June 1, 2020

RE: Phase 1 Westgate – 1309 Carling Ave
Re-submission based on Hydro comments

As requested, the following provides a detailed and itemized list of changes to the Site and Landscape Plan for Westgate Phase 1, resulting from Hydro One comments and their request to make adjustments to the Site Plan. These include:

**DRAWING NO.**  
**L1.1**

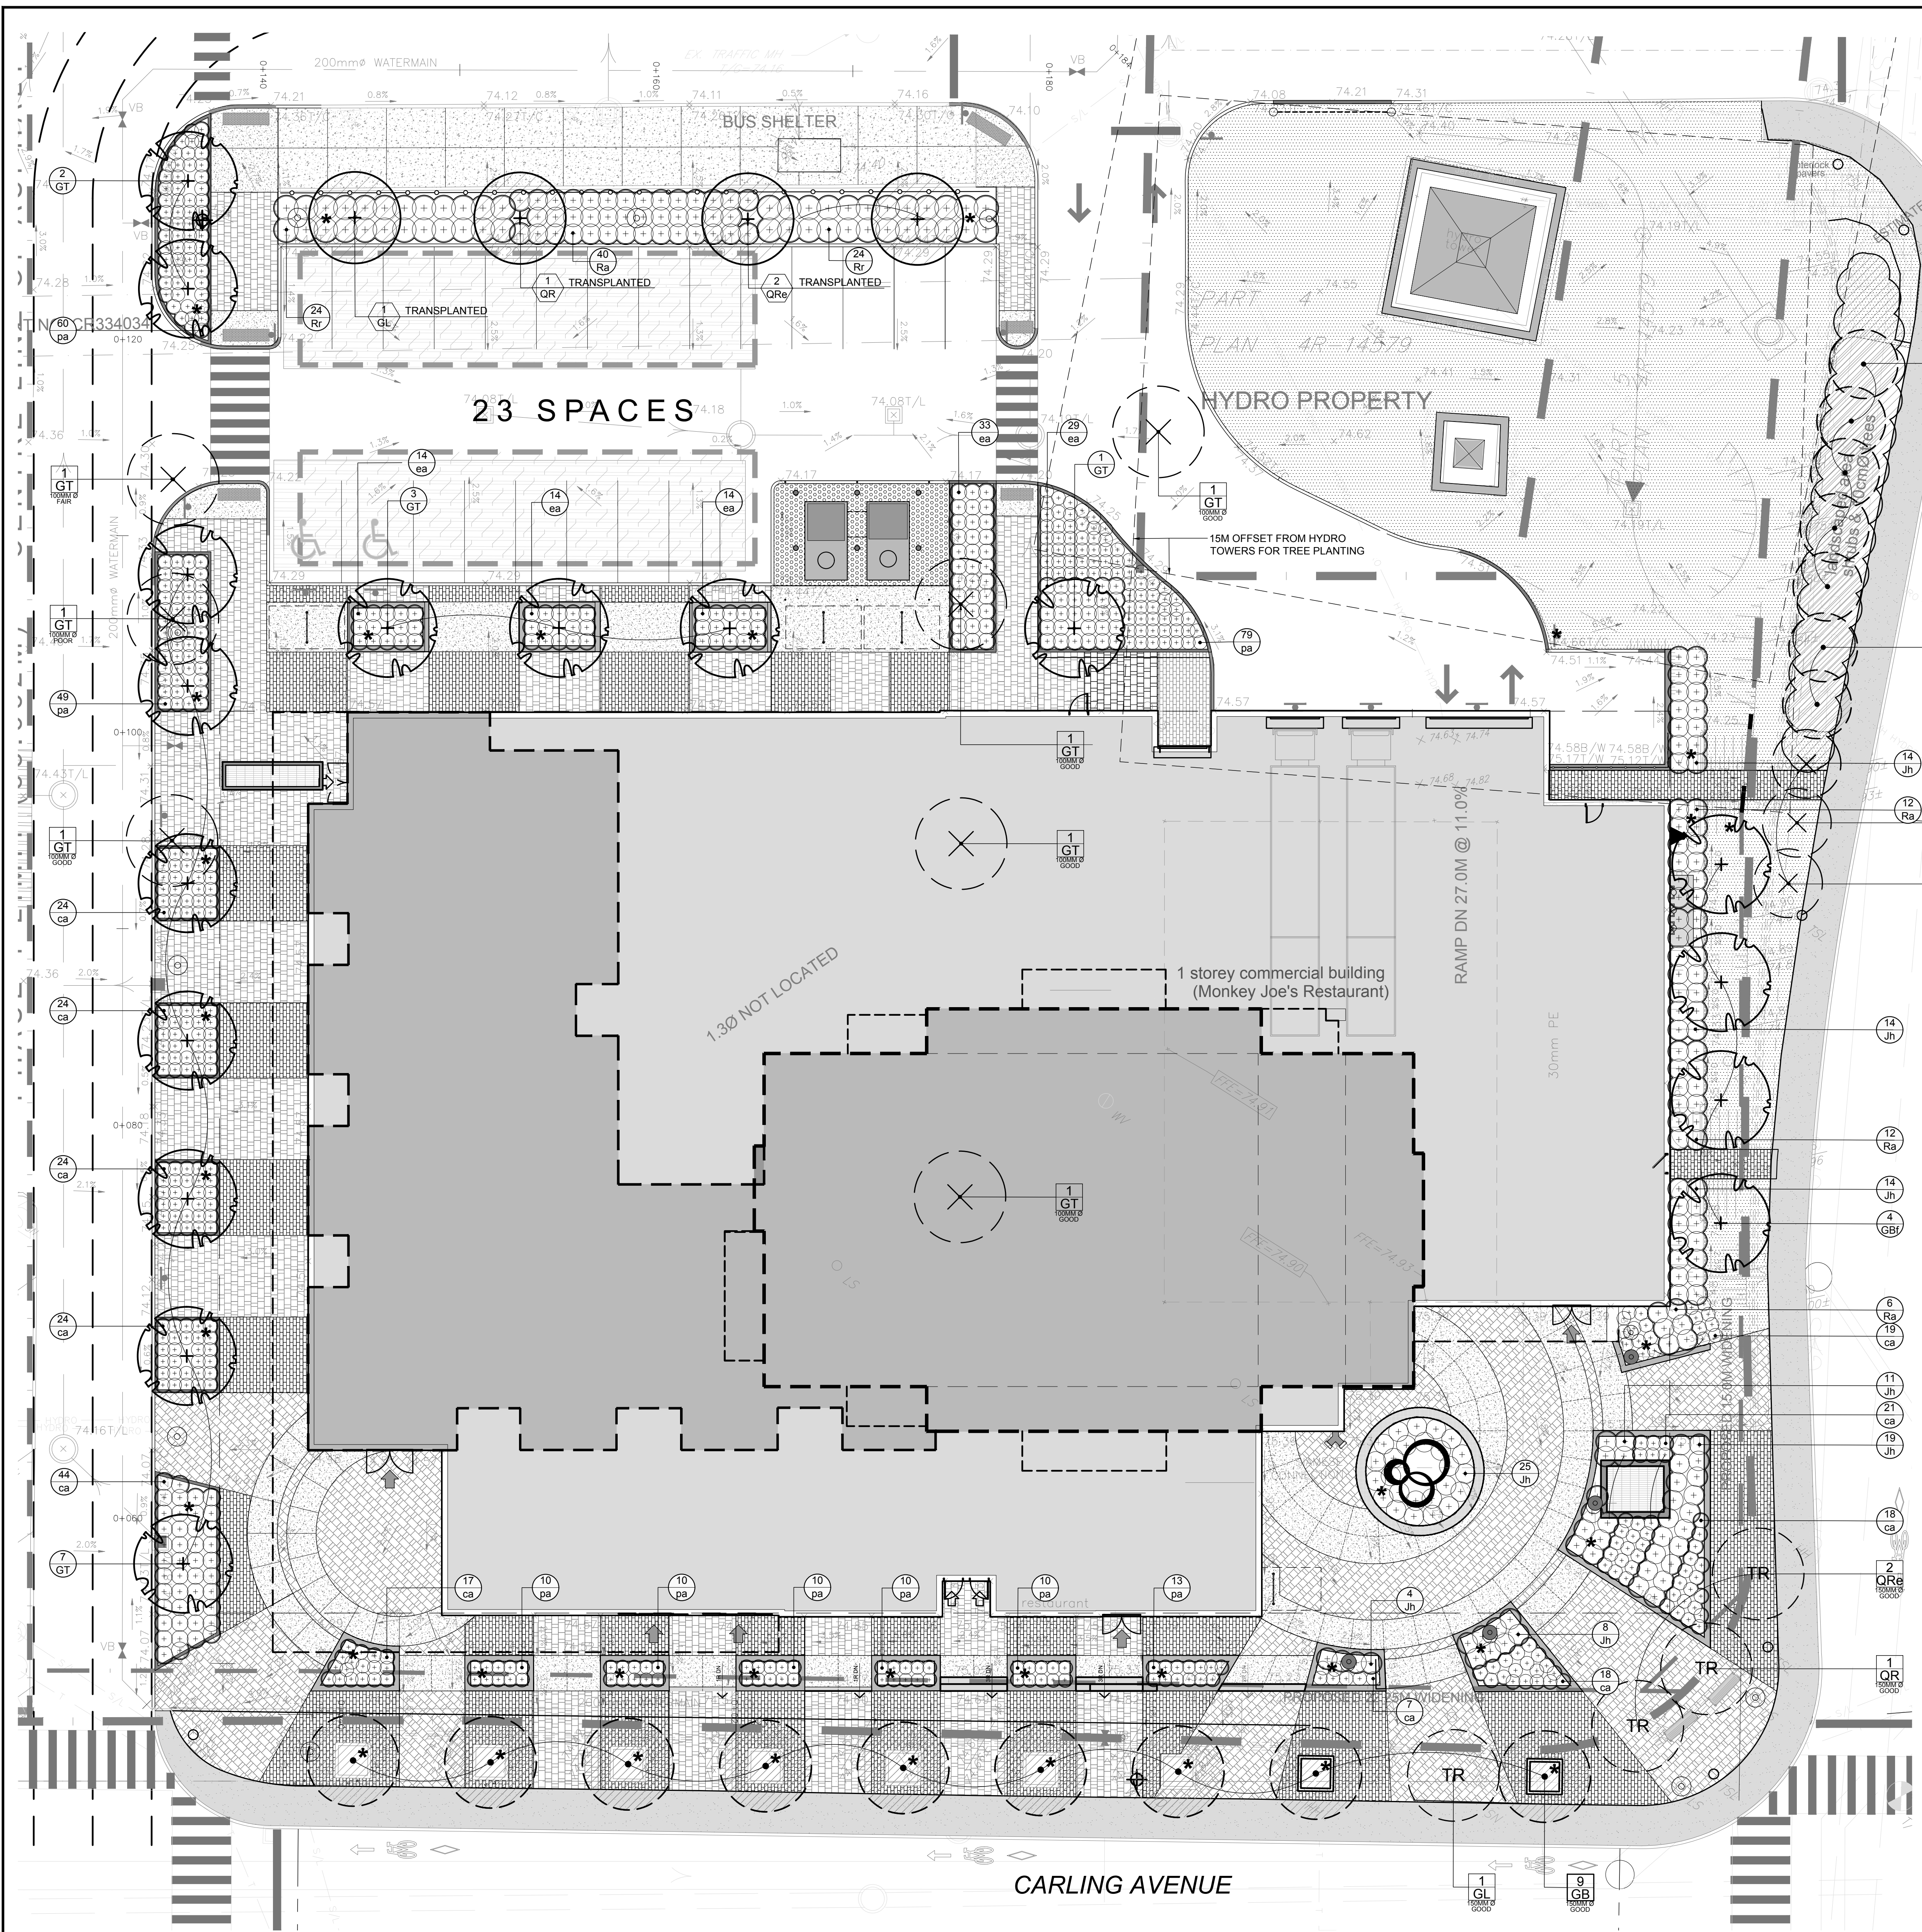
- / Minor landscape revisions. (i.e. paver patterns, courtyard planter location, tree spacing).
- / Planters spacing along Carling (between building and sidewalk) have been adjusted to work with the door locations better.

- / Planters at the small courtyard at the intersection of Carling and Merivale have been adjusted in coordination with the parking garage intake shaft.
- / Two proposed trees in the small courtyard have been removed.
- / Tree next to the residential entry has been removed.
- / Gate into grass area west of hydro tower added as required by Hydro One.
- / All proposed trees below the hydro lines (5 trees) have been deleted as required by Hydro One.
